**Planning Department
Transportation Development Services Section**

Re: Certification Submittal for Certificate of Occupancy for
Liberty Dialysis – Rio Rancho (A-11/D013)
5751 McMahon Blvd. NW
Engineer's Stamp dated 09-11-13

The Letter of Certification submitted on 09-11-13 is **Not Sufficient** for acceptance by this office for a Permanent Certificate of Occupancy (C.O.). The following items need to be addressed:

SITE PLAN

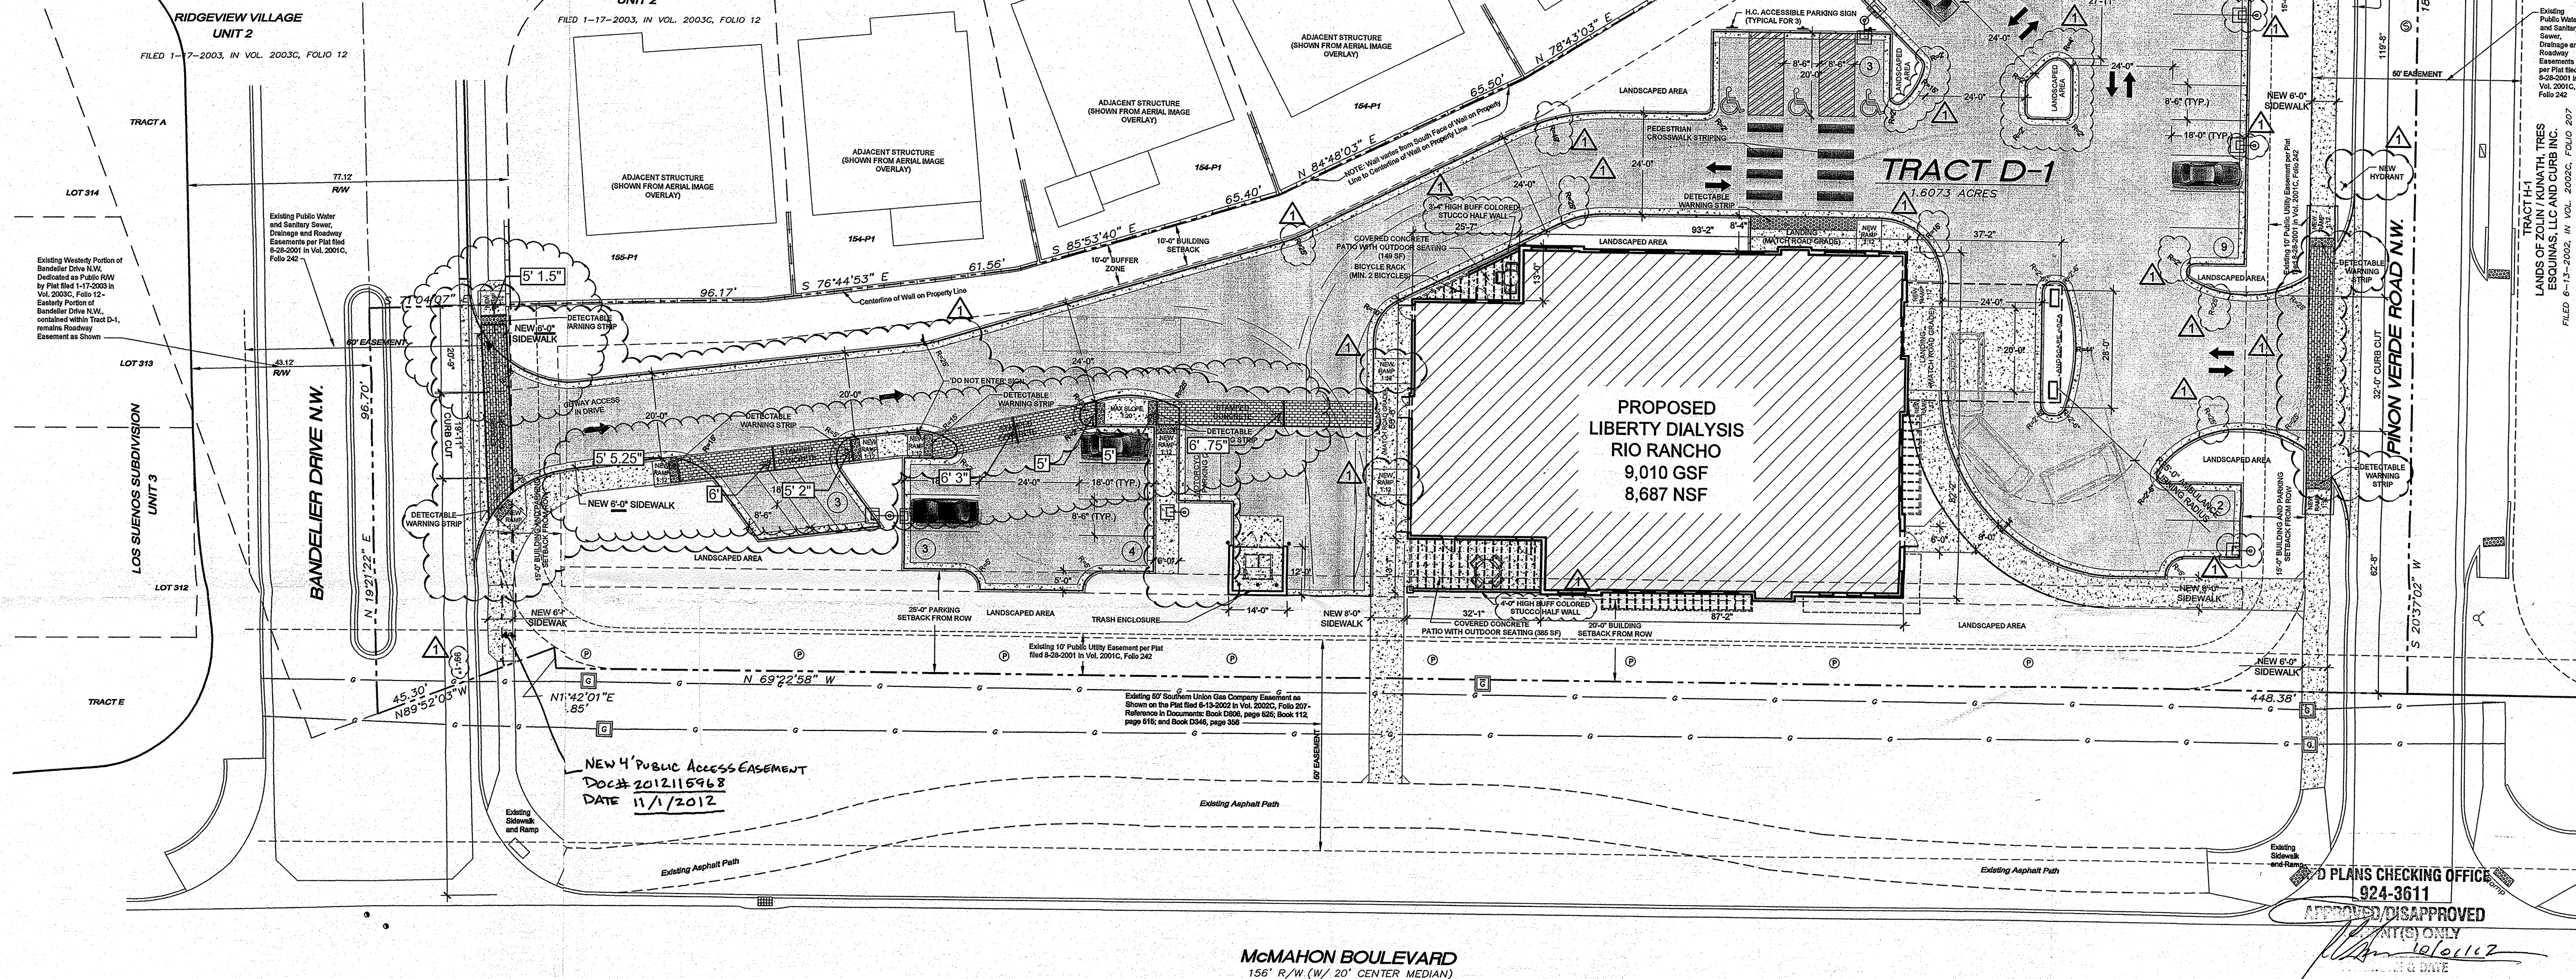
- Pinon Verde frontage: The detectable warning surfaces need to encompass the whole 6-foot width on both the north and south unidirectional ramp; the buffer between ramps and roadway curbing need to be filled in to the top of surface .
- Bandelier frontage: The northern ramp/sidewalk width needs to be 6-feet in width as called out on the approved site plan (measure at 5'-1.5"); there needs to be 6-foot width of sidewalk connection from street to back entrance of building(measurements fluctuate between 5'-2" to 5'-10" width/opening on ramps/sidewalks) as called out on site plan; the buffer between unidirectional ramp and curbing need to be filled in to the top of surface (northern ramp).
